National Infrastructure Planning
Net Zero Teesside DCO Case Team

Date
23 June 2022

Application by Net Zero Teesside Power Limited and Net Zero North Sea Storage Limited (the Applicants) for an Order Granting Development Consent for the Net Zero Teesside Project (the Project)

Deadline 3 Submission and Request to Attend Hearings - South Tees Development Corporation

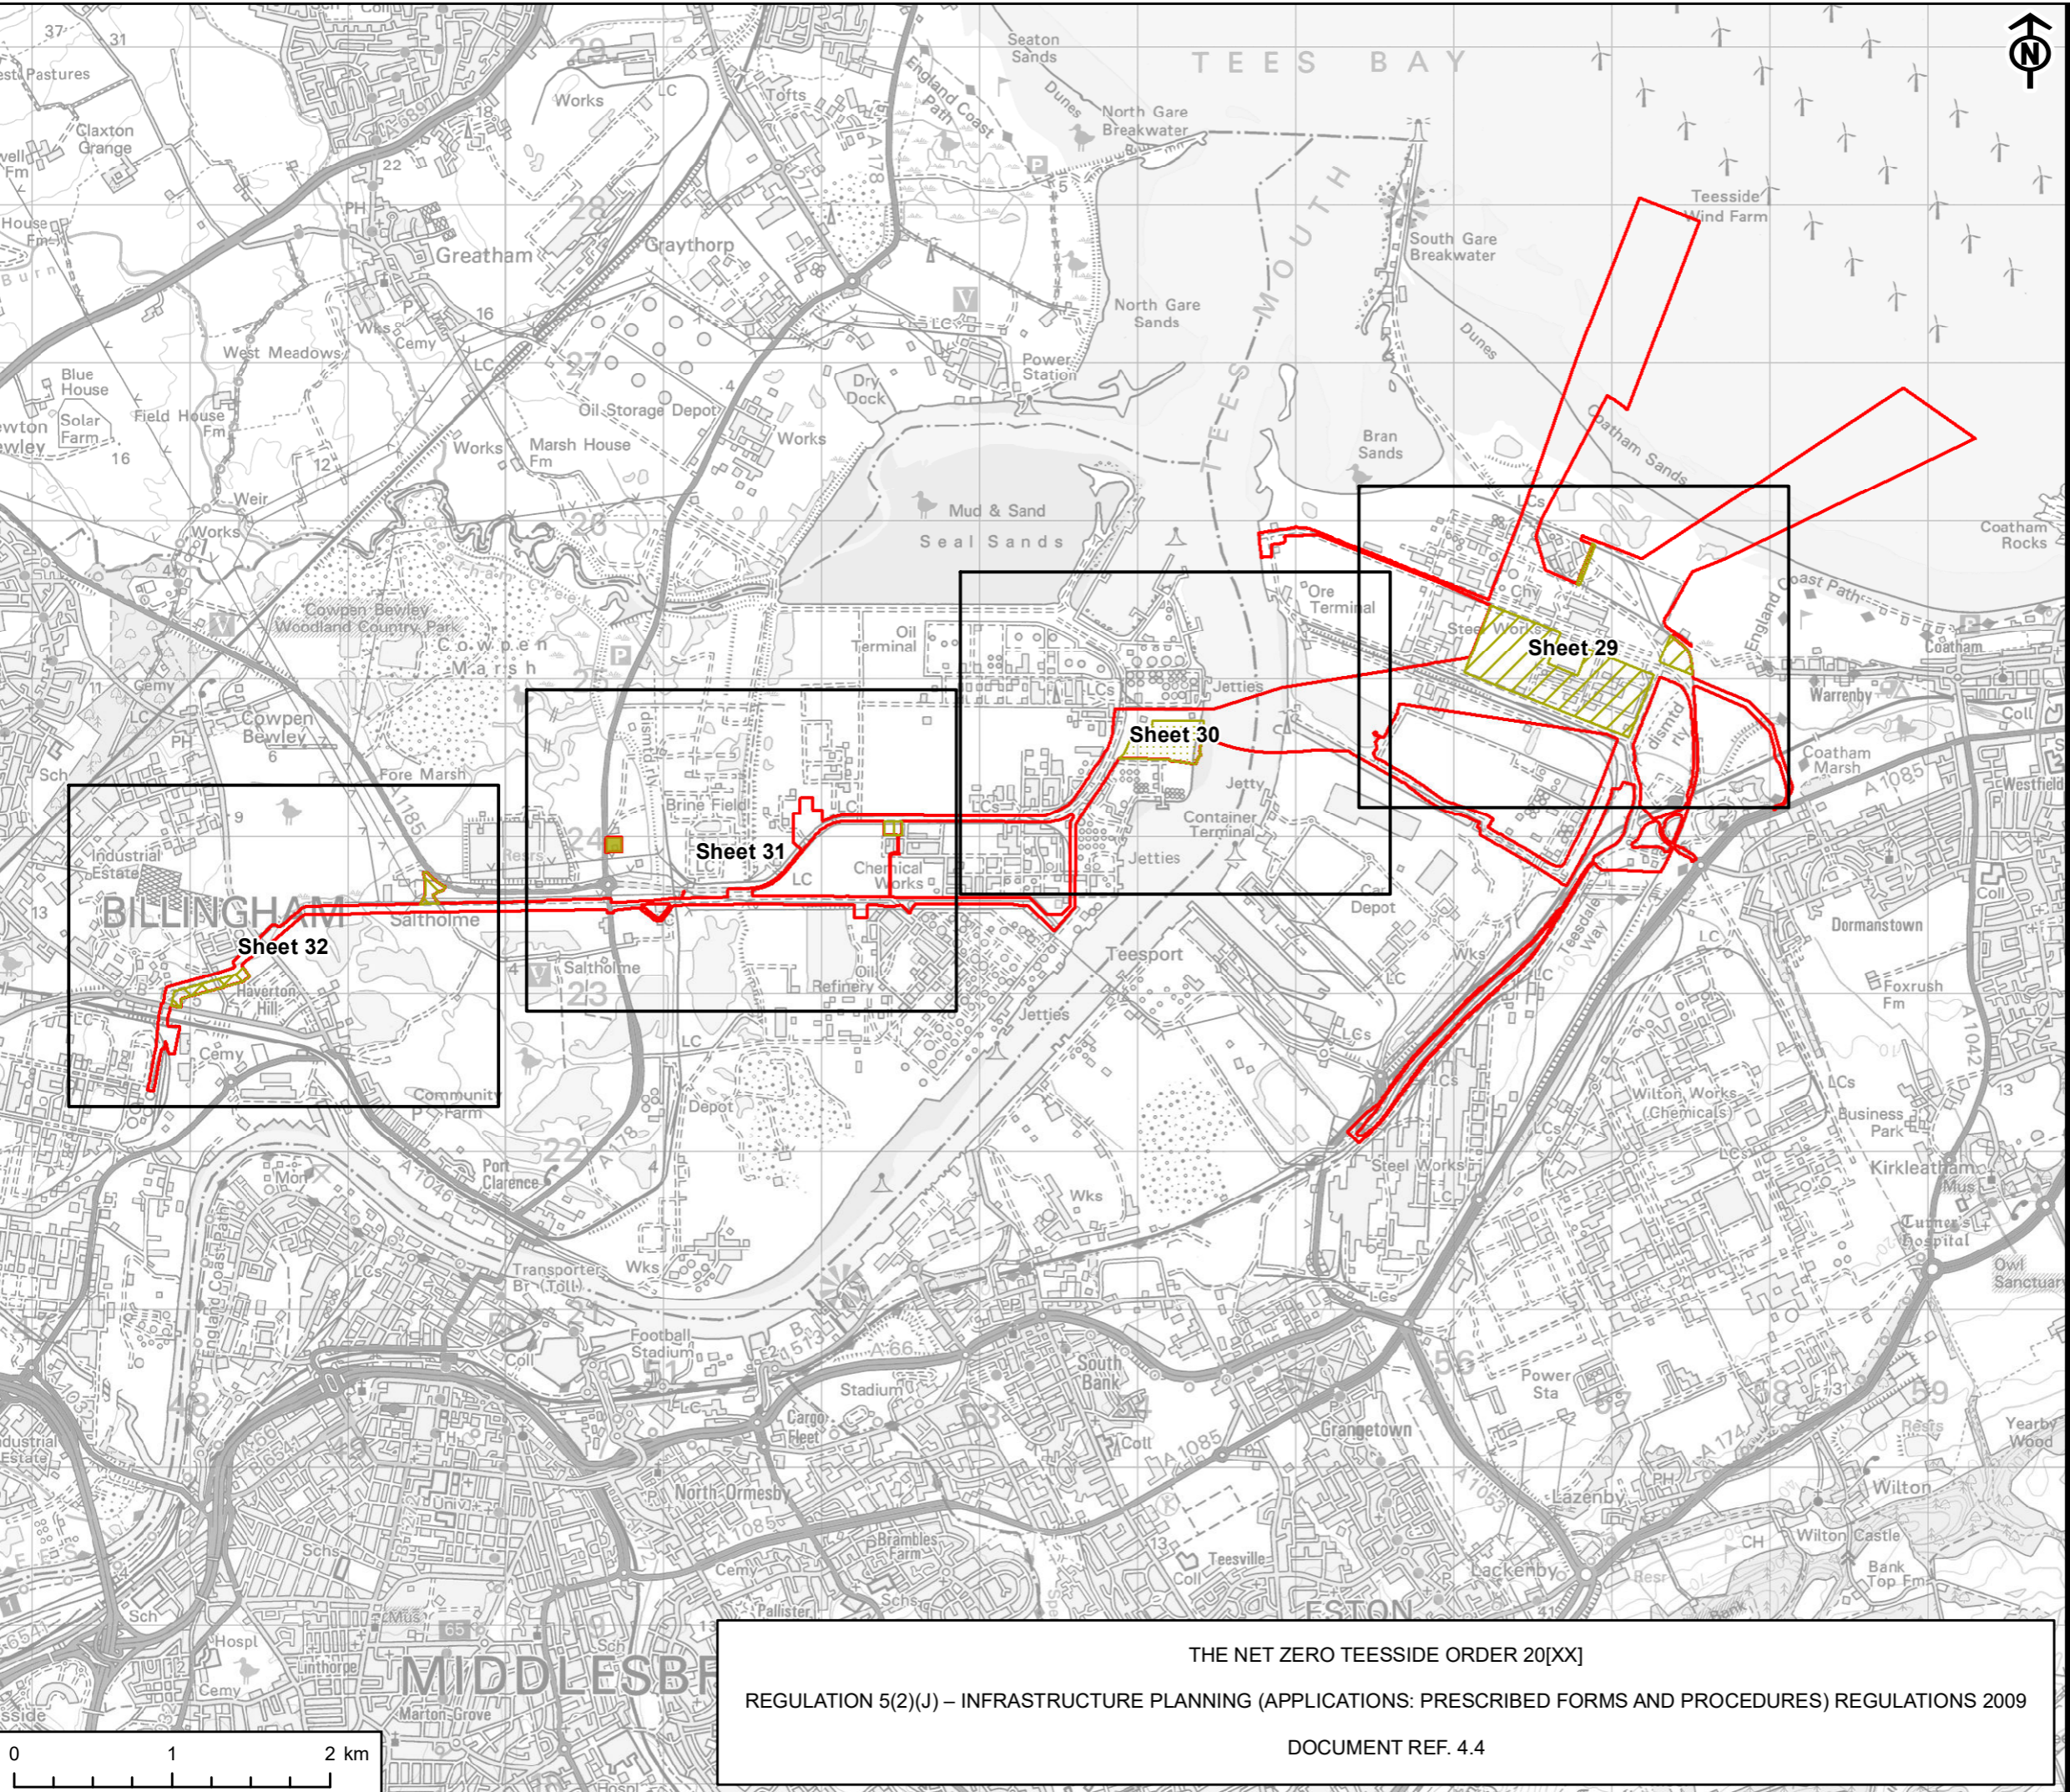
The Statement of Common Ground between the parties submitted at Deadline 1 [REP1-007] made clear that the extent of Order Land would be reduced for Work Nos. 9A and 9B, as some of this land is no longer required. STDC welcomes the reduction in scope of powers proposed at Plot 292 from permanent rights to temporary possession. However Plots 292, 293, 295 and 291, 298, 299, 309 have not been reduced in size. STDC requires a reduction to be made to the Order Limits at the next available deadline to reflect that some of these areas are not required by the Applicants.

GEN.1.9 – Chapter 5 of the ES (Construction Programme and Management) [APP-087] still fails to provide details as to the location and quantities of any arisings being stored / stockpiled in the Order Limits on lay-down areas or other STDC land subject to temporary possession powers. There is no apparent obligation e.g. in the Schedule 2 Requirements, to ensure that residual arisings are removed within a set period so as to avoid unnecessary sterilisation of land because of stockpiling thereon. STDC continues to strongly resist the sterilisation of its land being used for stockpiling purposes.

- KEY
- Order Limits (Site Boundary)
 - Detailed Sheet Number - Work No. 10 - Access and Highway Improvements
 - Areas within which each Work Number may be constructed
 - Work No. 10 - Access and Highway Improvements

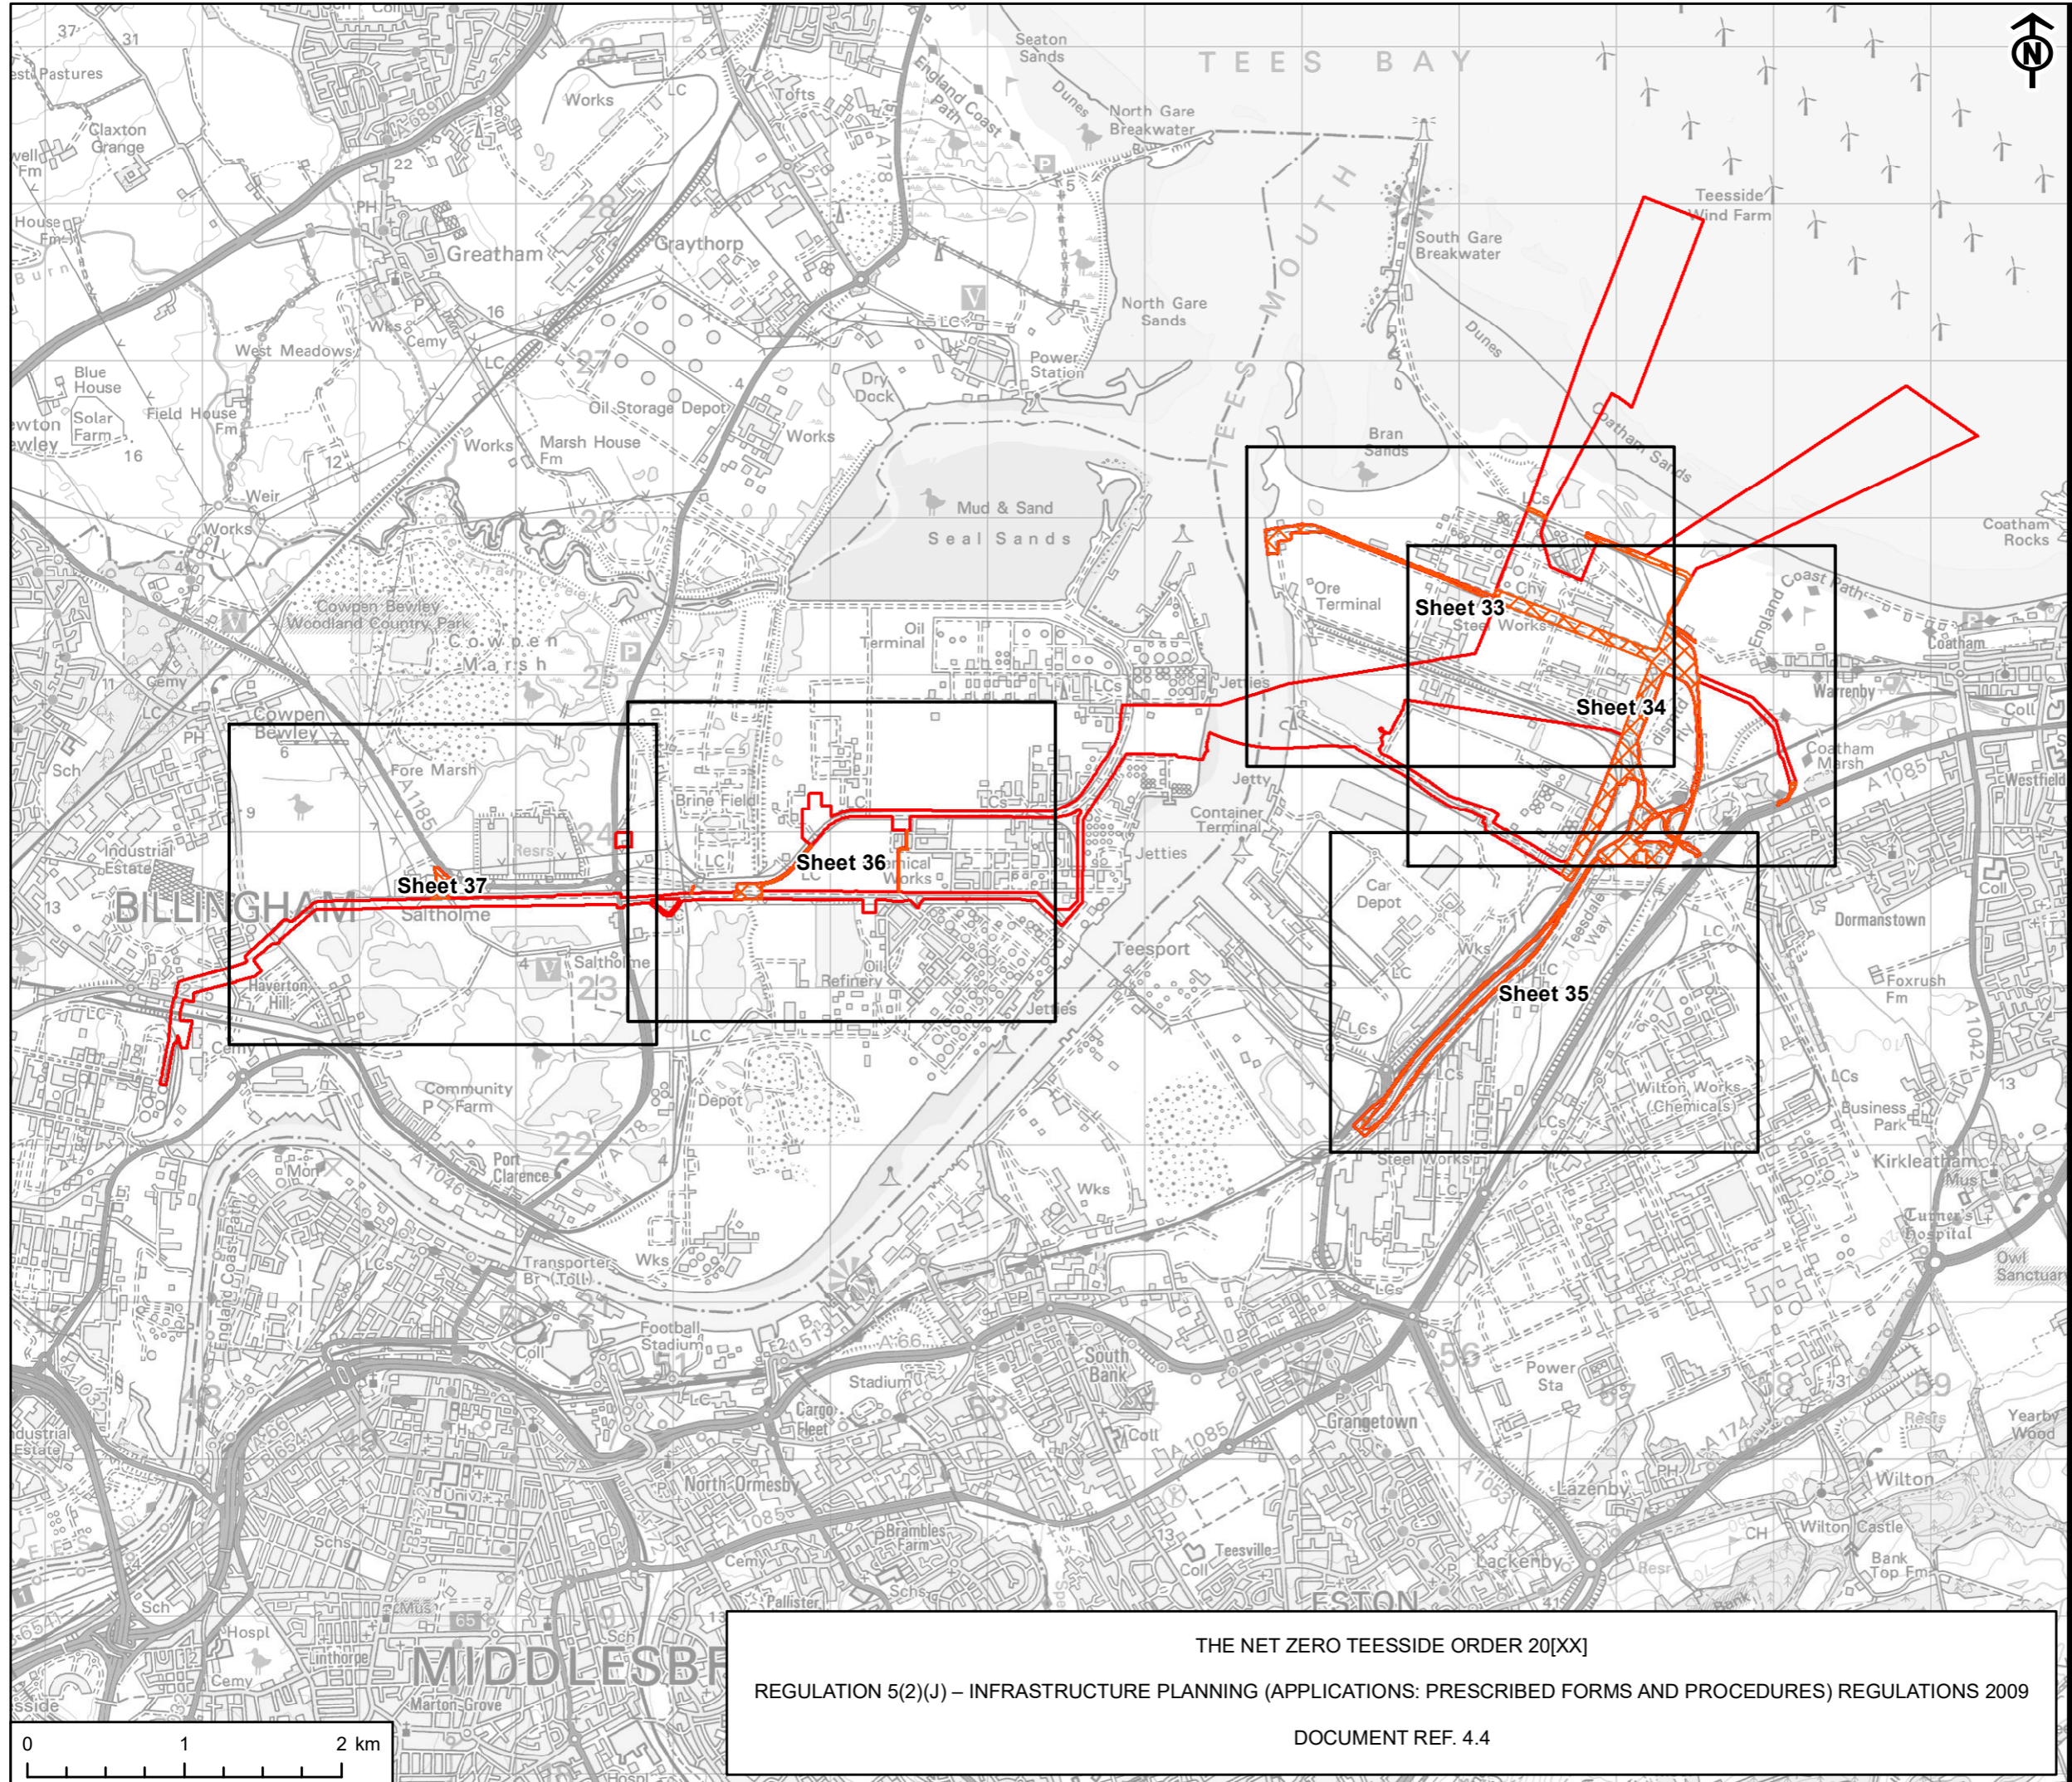
STDC's Written Representation referred to the existence of reasonable alternatives, including means of construction access. In particular STDC draws the Examining Authority's attention to the reasonable alternative to the access currently proposed at Tees Dock Road (plots 274 and 279) set out in paragraph 3.9-3.12 of STDC's Written Representation.

TT.1.2 – STDC would like to clarify that the Tees Dock Road access is an unused, secured gate, and is not suitable nor safe as a form of construction access as compared to the alternative being offered by STDC (Lackenby Gatehouse). STDC queries whether the response from the Applicants addresses peak construction period movements, which seems to have been overlooked.
